Roof Deck Seating Plan - Bayside Bowl - 1452

From: Jeanie Bourke <jmb@portlandmaine.gov>
Subject: Re: Roof Deck Seating Plan - Bayside Bowl - 1452
Date: April 26, 2017 at 10:00:54 AM EDT
To: Ryan Senatore <ryan@senatorearchitecture.com>
Cc: Justin Alfond <jalfond@gmail.com>

1. I looked back at the original and amended approvals for the rooftop area and the seating layout has changed quite a bit. There are now banquet benches, picnic tables and standing barrel tables where there were all tables and chairs. There now is a significant open area that would be classified as standing room that will add to the occupant load and the percentage of ADA seating. Also, from the previous plan there is a dashed line for the deck and canopy, this new plan does not show the extended canopy. Also, is the whole assembly area decked over at the same level or is there a transition of levels?

SHEET TITLE:
RE-DESIGNED
ROOF TOP DECK

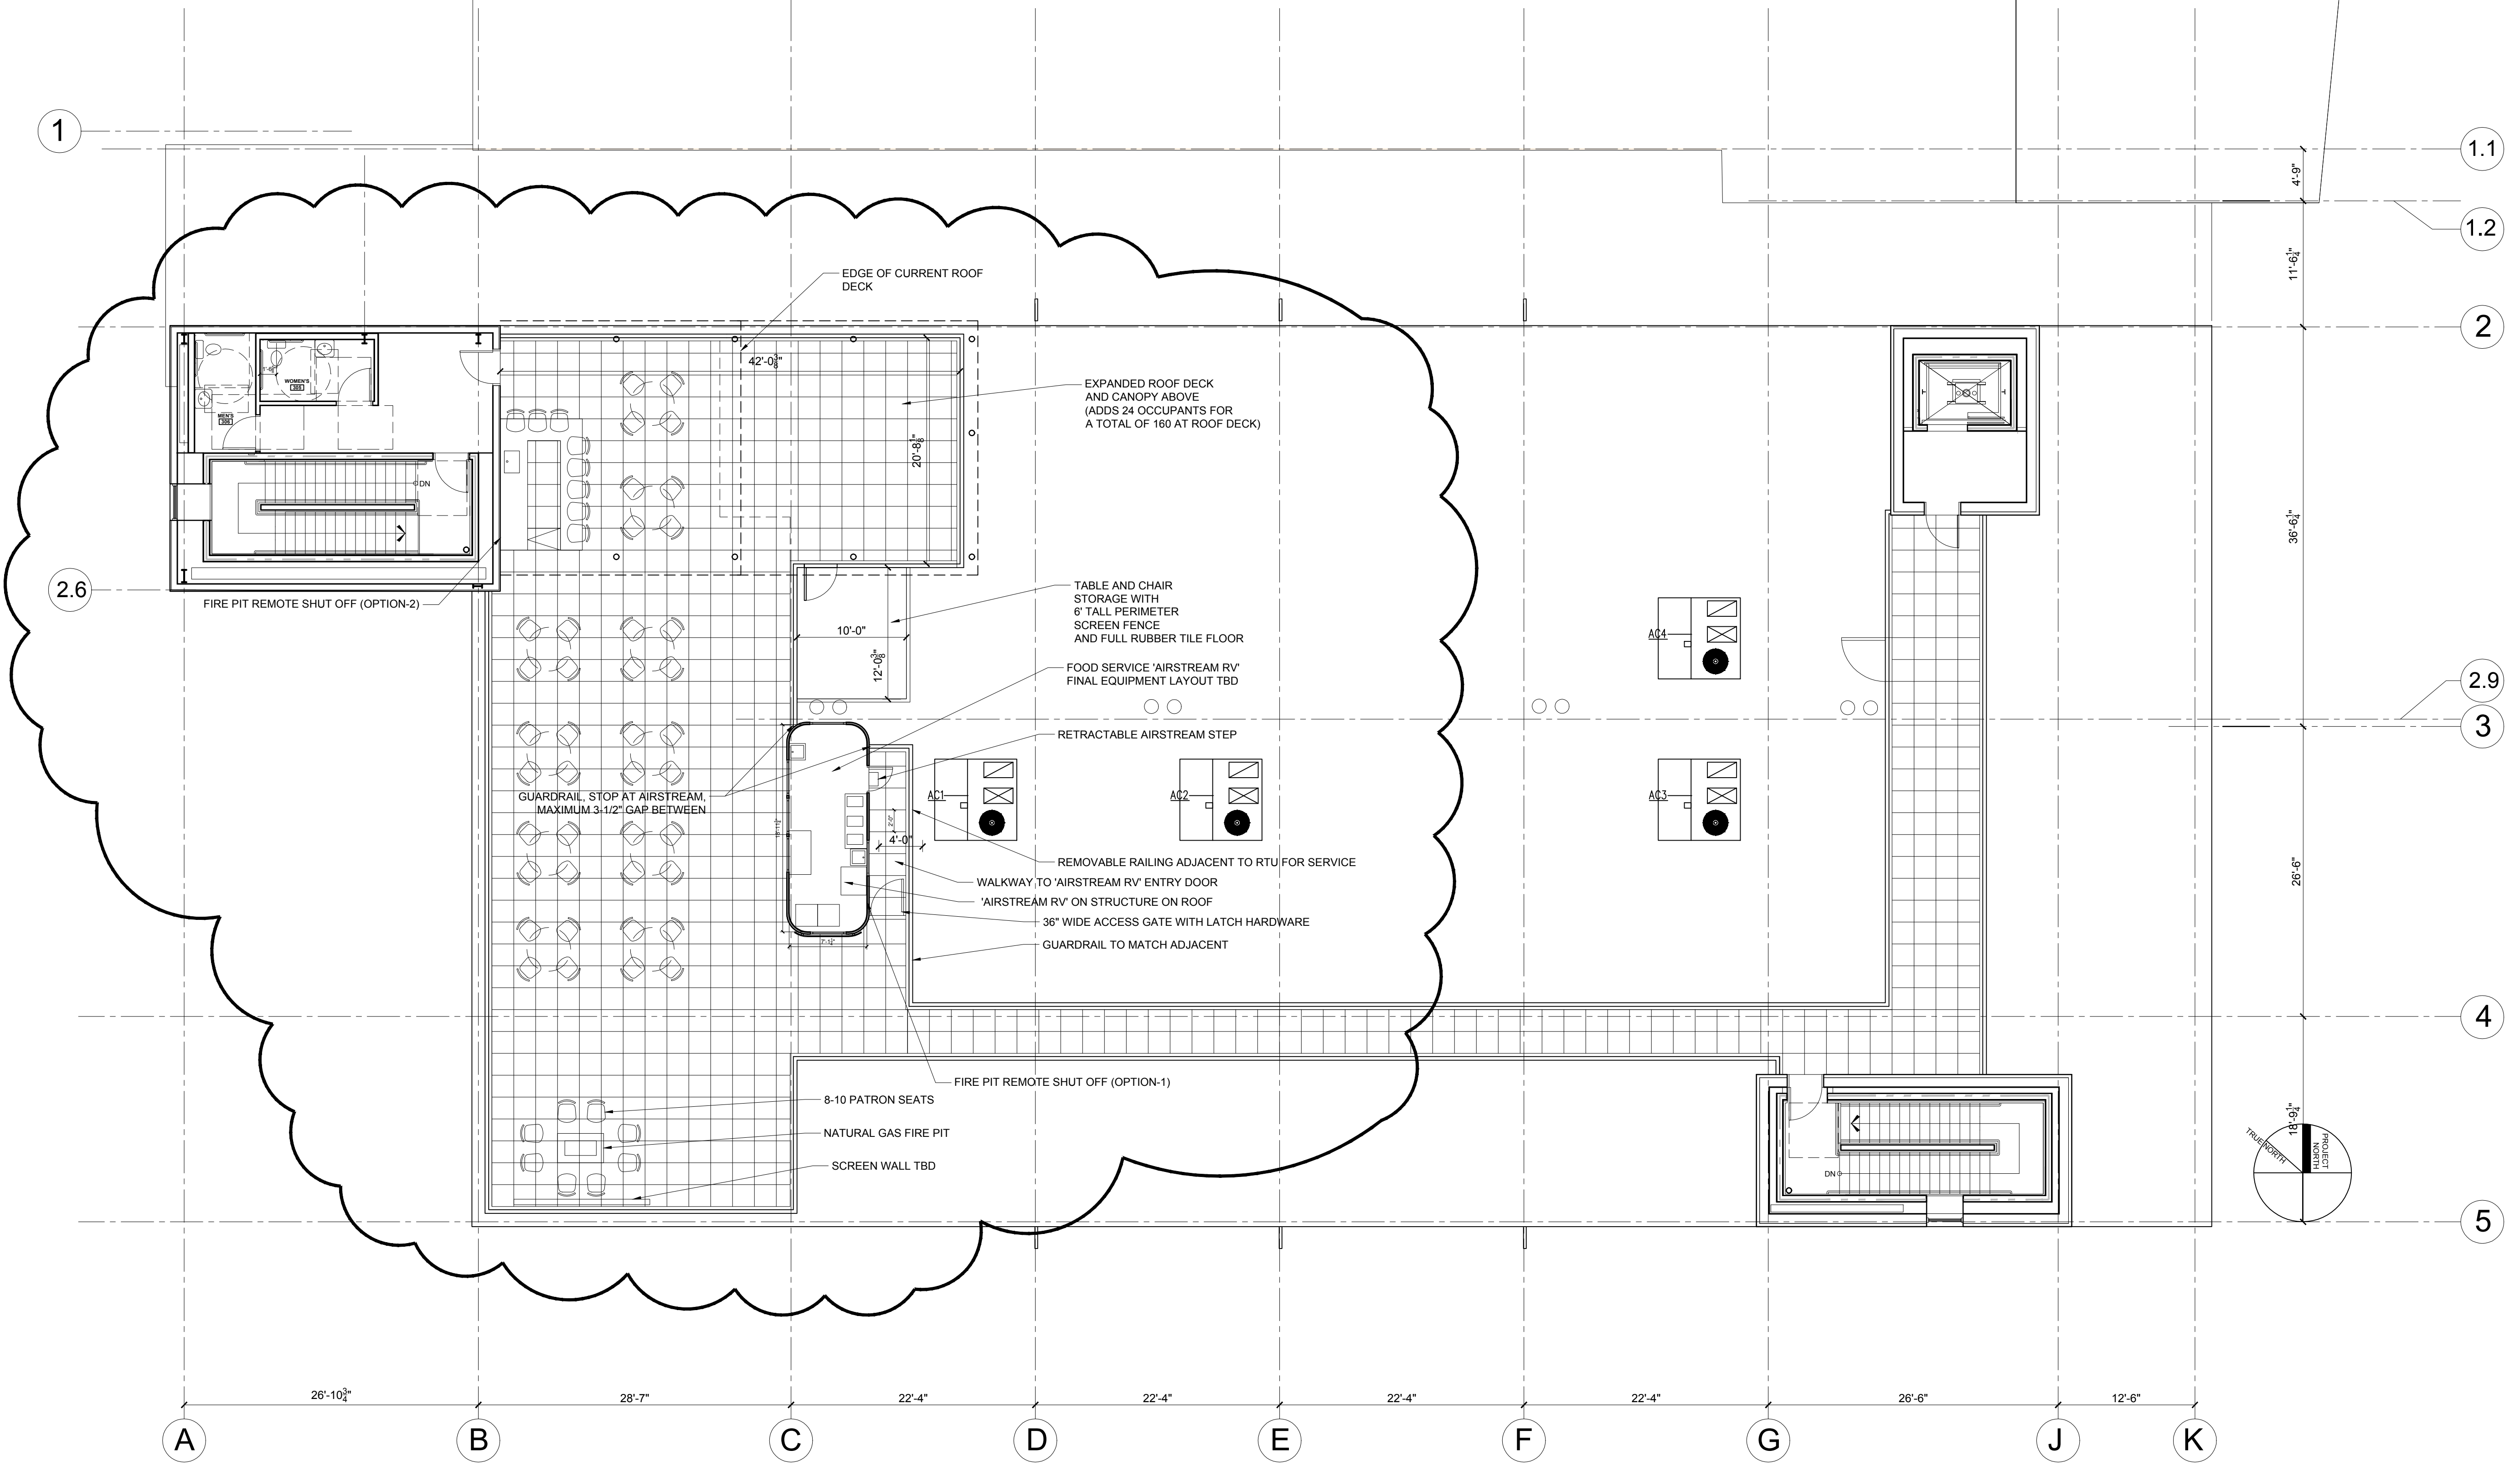
2. The 5% ADA seating also has a dispersion requirement to allow for inclusive seating in the various areas, bar and picnic tables, please address this.

3. What is the food service plan in this area, will there be wait service, or is it more like window order take out? I'm just trying to get a sense if there will be self service counters that need to comply with ADA standards.

There is 636 sf of standing room space = 132 occupants, we have 389 sf at the picnic tables for 26 occupants, we have 394 sf of bench and table seats for 27 occupants and 13 seats at the bar for a total of 198 occupants at the roof level.

The canopy was not extended so this plan is accurate.

The entire roof deck is at one level.

We have shown the Variety of ADA seating on the attached plan

The food service is at a window, we have added notations for the ADA height service window at the RV
